From: Nicola Spencer
Sent: 28 February 2020 10:16
To: Clive Hawkins
Subject: RE: Planning reference BR/180/19/PL - London Road, Bognor Regis.

Further to my recent email I know that many premises along London Road have complicated rights of access to their properties and these could well be impacted by the proposed development. By example the Block plan and site plan drawing 637.06 REV A shows the residential building almost touching the adjacent structure to the rear of 33 London Road. The site plan drawing also notes a fire escape door in the structure to the rear of 33 London Road. I understand that this door forms part of a designated rear fire escape route for the adjacent Halifax Building Society at 31a London Road.

I have recently noted the above planning application reference 37 London Road. In briefly looking at the application documents and plans it is clear from the Design and Access Statement that the applicant proposes to access the residential unit from the car park behind.

Dims added	Aug 19		A
Revision	Date	By	Rev. No.
Client			
Project RO 37 London Road, Bognor			
Title Block Plan			
CLIVE HAWKINS ARCHITECTS LTD DESIGN@CLIVEHAWKINSONLINE.COM Tel: 01273 245249			
Scales 1/500@ A4	Date 1.6.19	Drawn	Designer
Project No. 637	Dwg. No. Block Plan	Rev. No. A

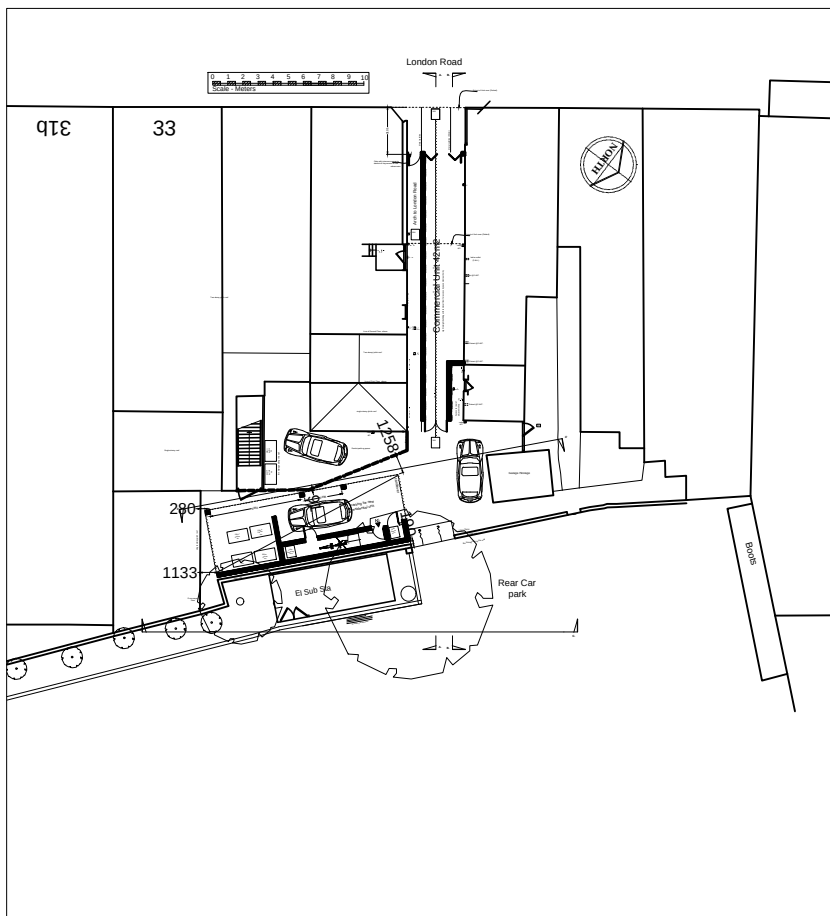
Further to our telephone conversation on 15 January, I still do not appear to have received an amended location plan showing the access to the public highway or the amended application form with Certificate B completed and re-dated. Regardless of any other issues, from a planning point of view, the car park land to the rear is not in your client's ownership and certificate B must be completed and notice must be served on the Property, Estates and Facilities Department at Arun District Council. This application has been on hold since 16 August and I cannot continue to hold this application while you and your client are resolving these issues. I am sorry but I have to close the file and I will arrange a refund.
